**Addendum No. 2**

RE: Contract # C204130

**Macon County (R-5734A)**

US-23/441 From US-64 To SR-1652 (Wide Horizon Drive)/SR-1152  
(Belden Circle) & Bridge # 314 Over Cartoogechaye Creek

PROJECT REFERENCE NO. R-5734A	SHEET NO. W-1
RW SHEET NO.	
ROADWAY DESIGN ENGINEER	GEOTECHNICAL ENGINEER
DOCUMENT NOT CONSIDERED FINAL UNLESS ALL SIGNATURES COMPLETED

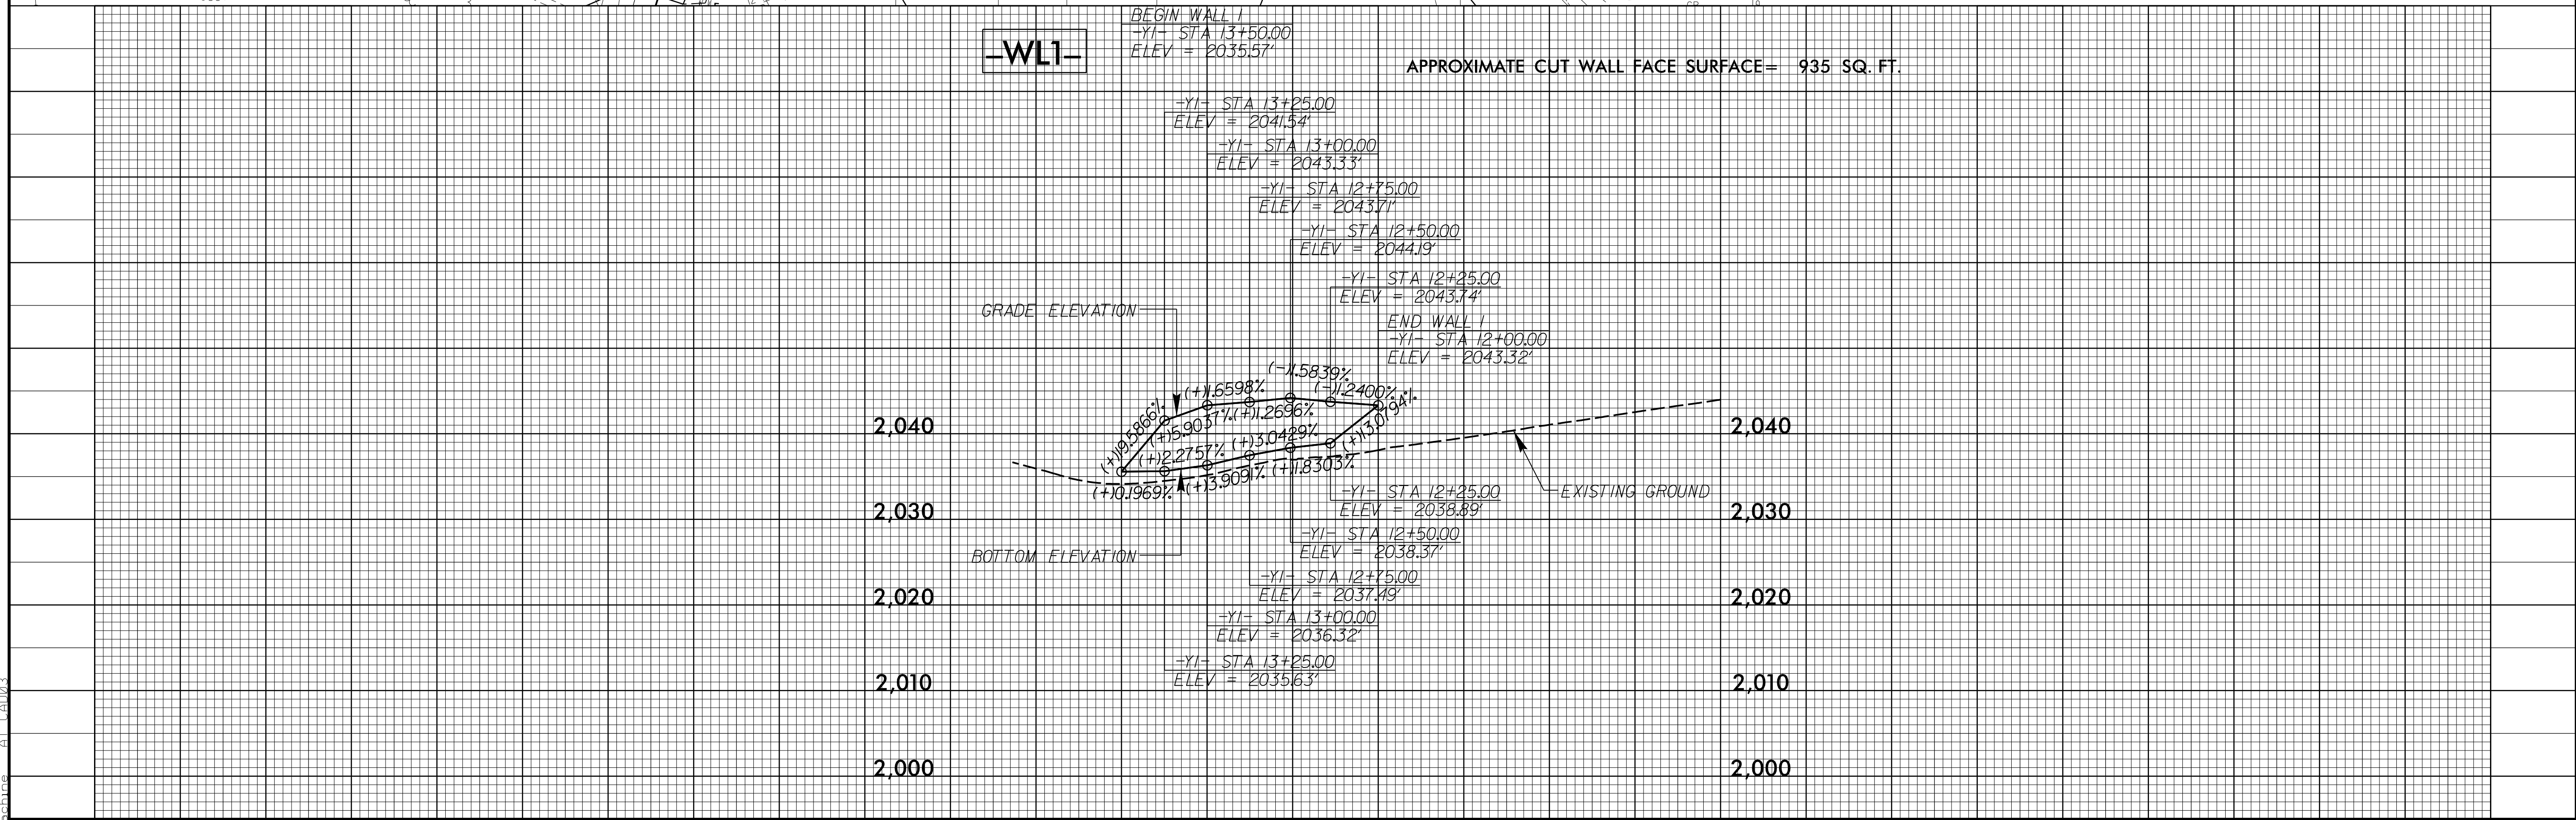
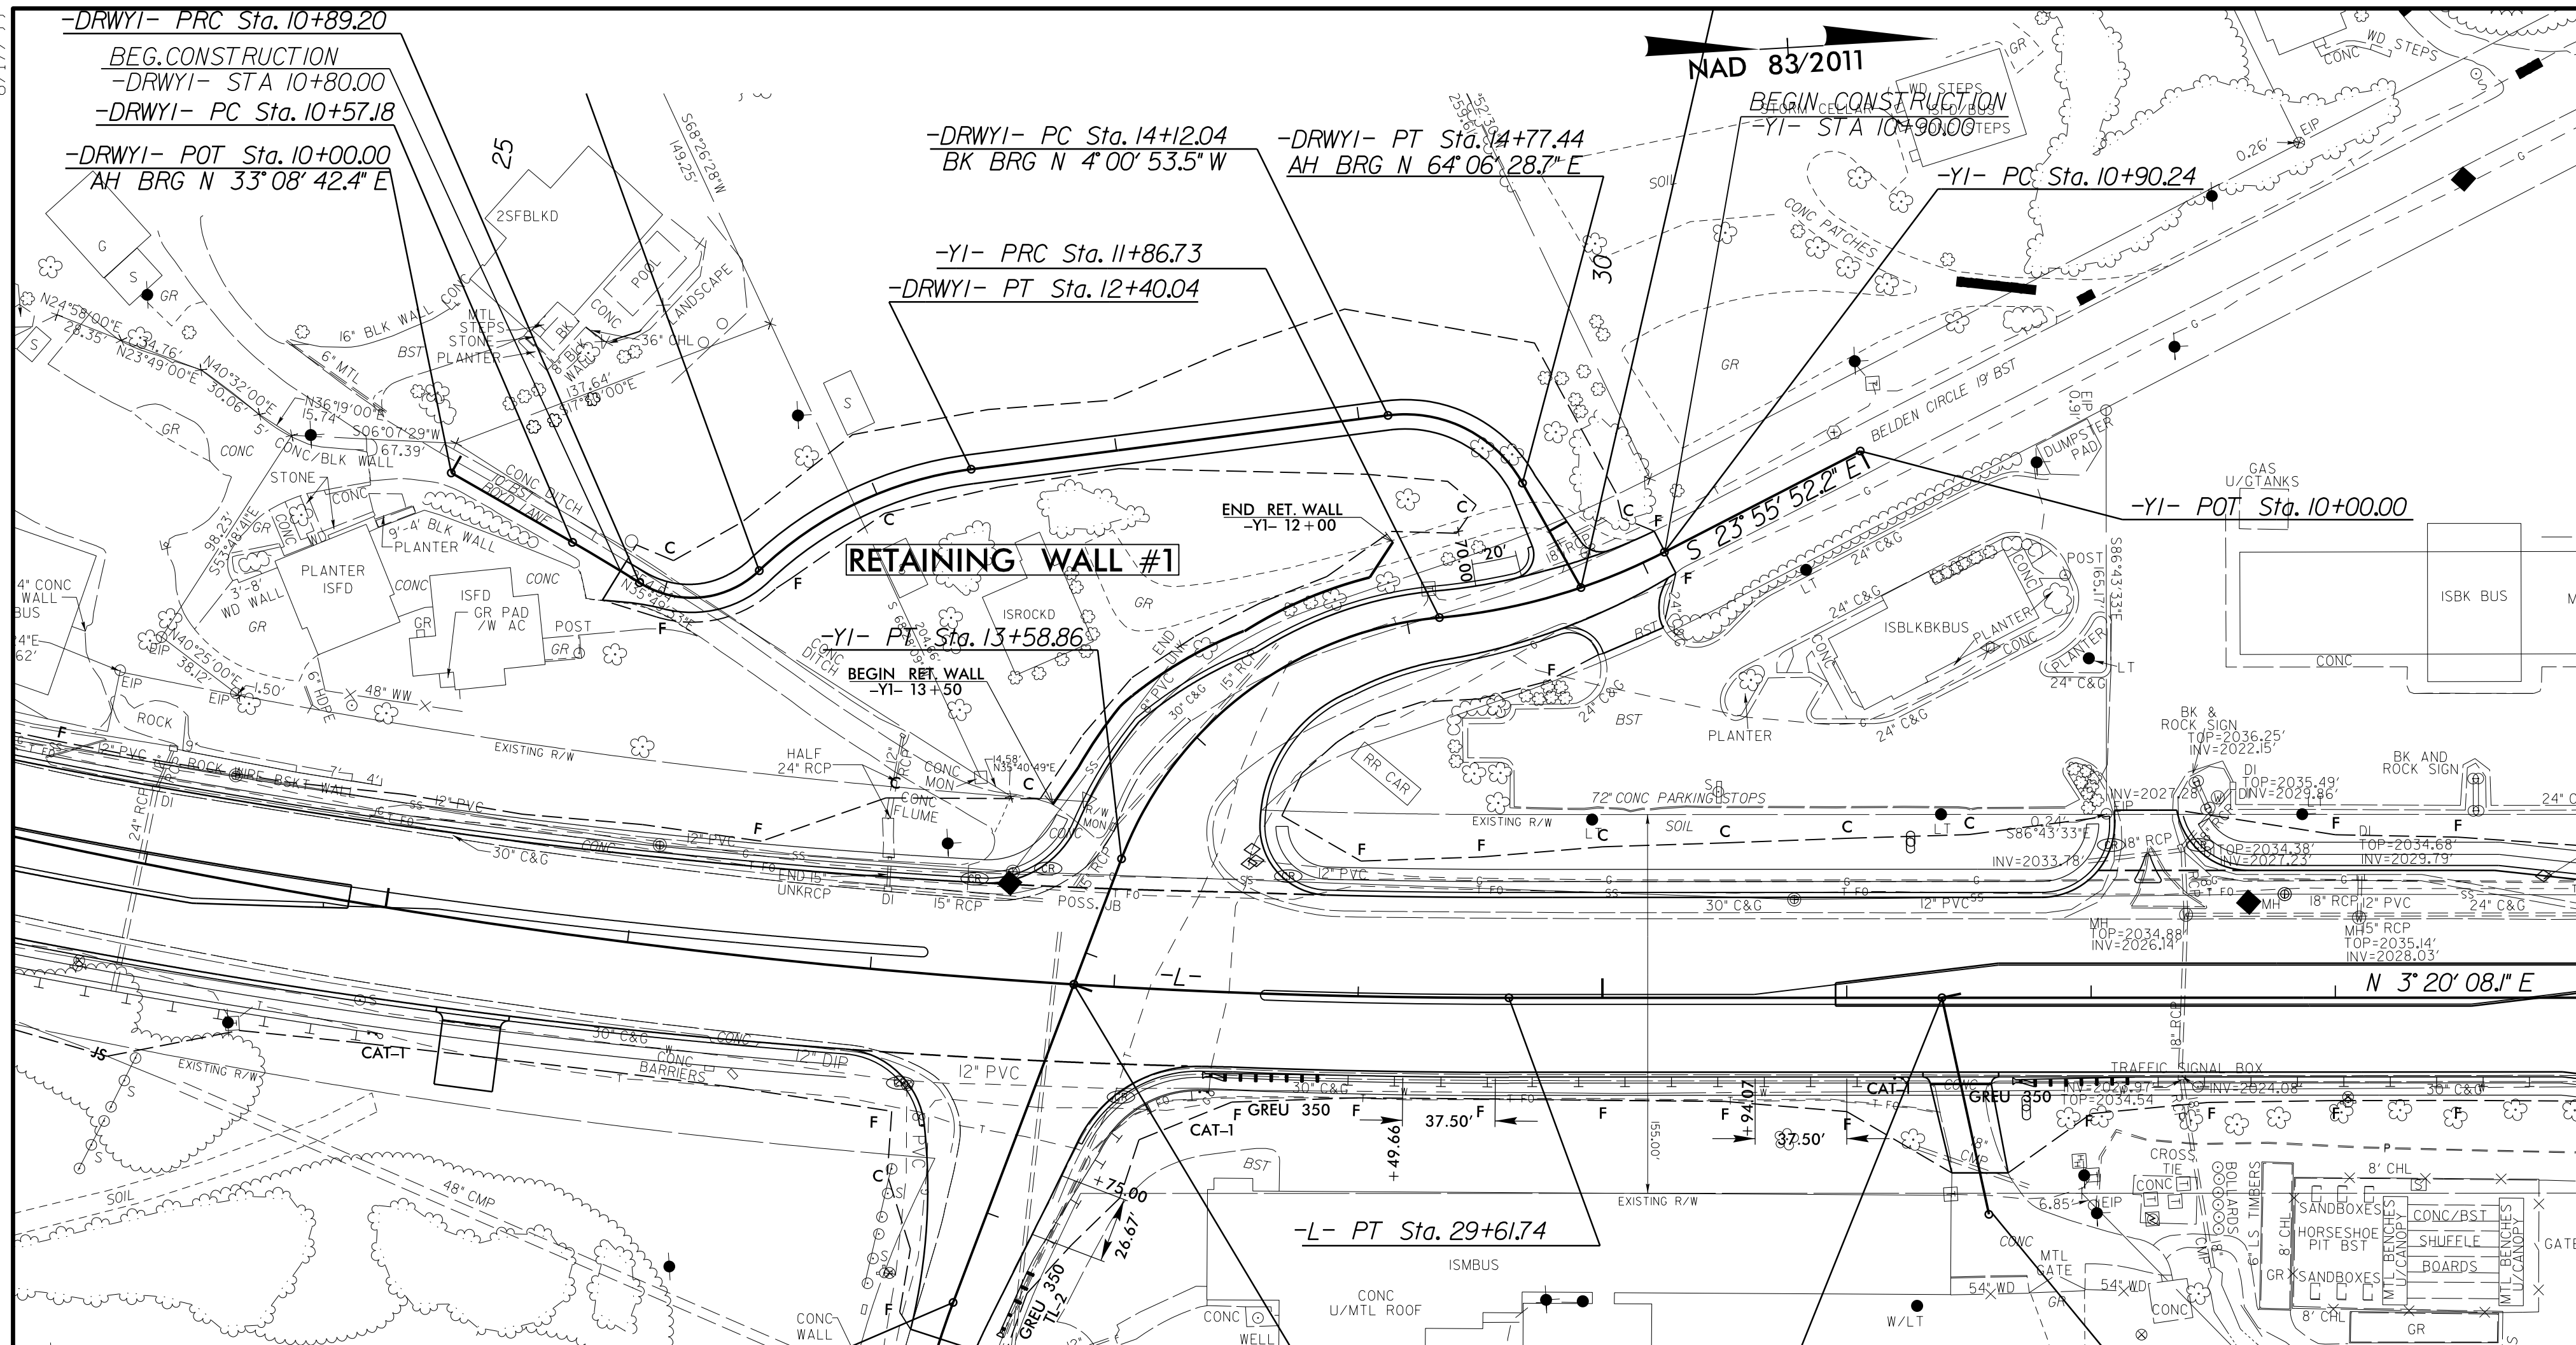
Sheet No.	Revisions
W-1	Revised the quantity of "Wall Face Surface"

Please void Sheet No. W-1 in your plans and staple the revised sheet thereto.
